SM ROCHA LLC  
COMMENT RESPONSE

## TRAFFIC IMPACT STUDY

**Owl Place Commercial  
El Paso County, Colorado  
PCD File No. CR221**

June 2022  
Revised:  
March 2023

**Figure 4**  
**BACKGROUND TRAFFIC - YEAR 2024**  
Volumes & Intersection Geometry  
AM / PM Peak Hour  
(ADT) : Average Daily Traffic

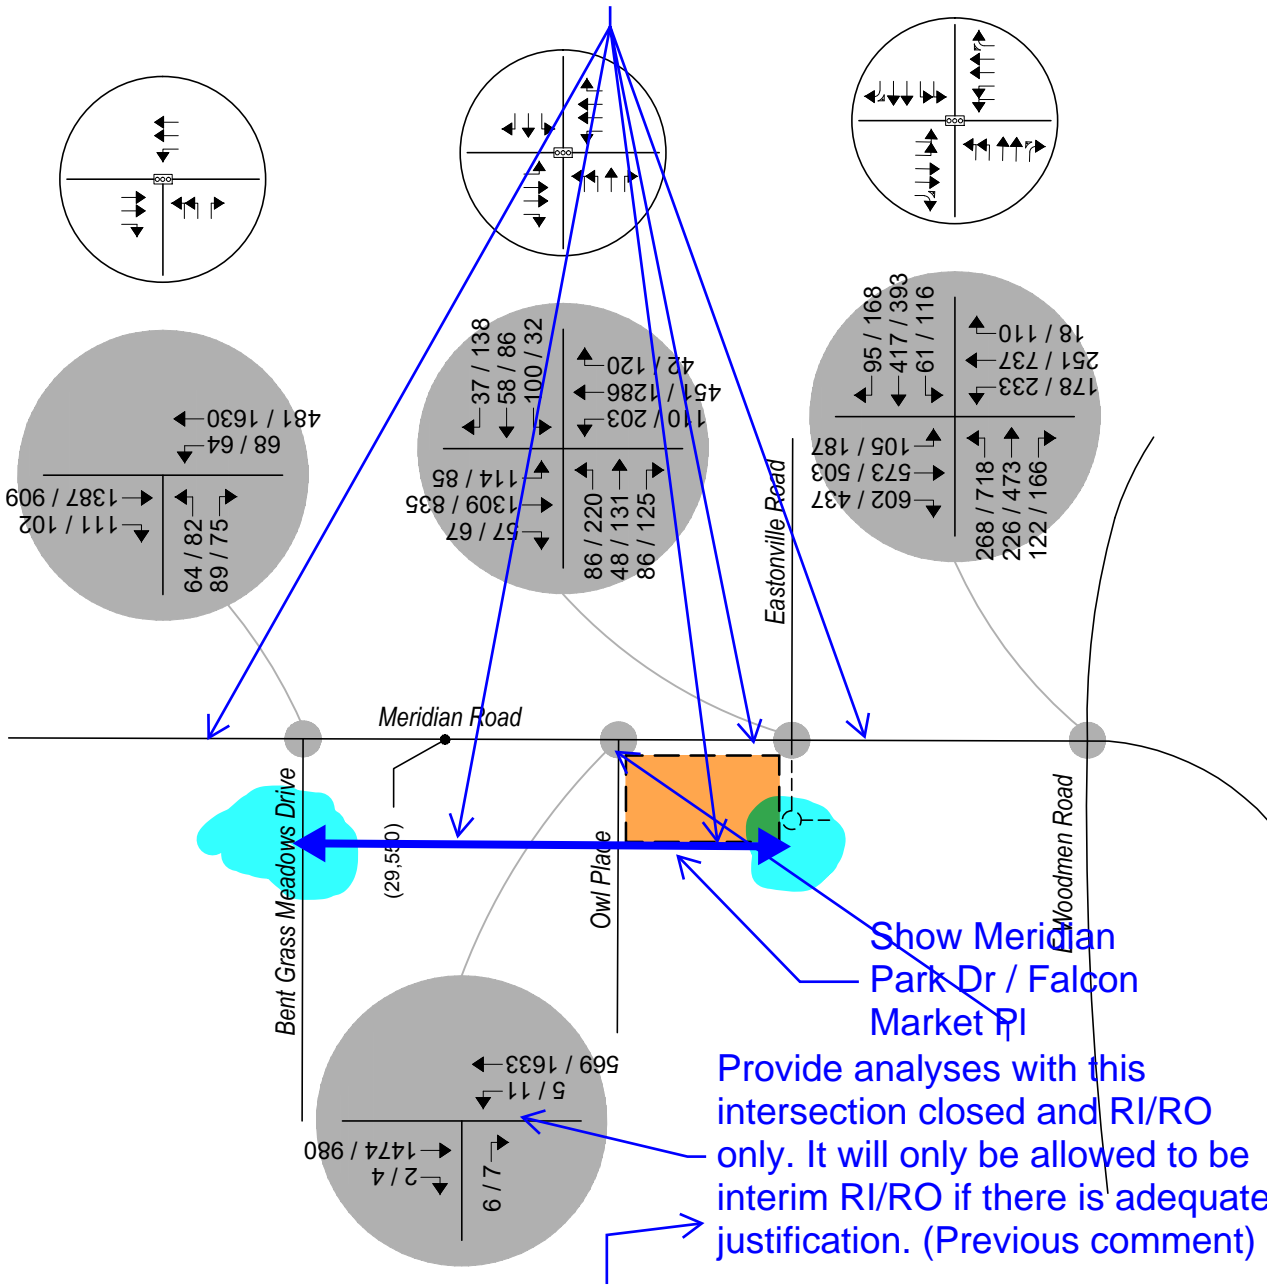
delete the movements to and from the east side
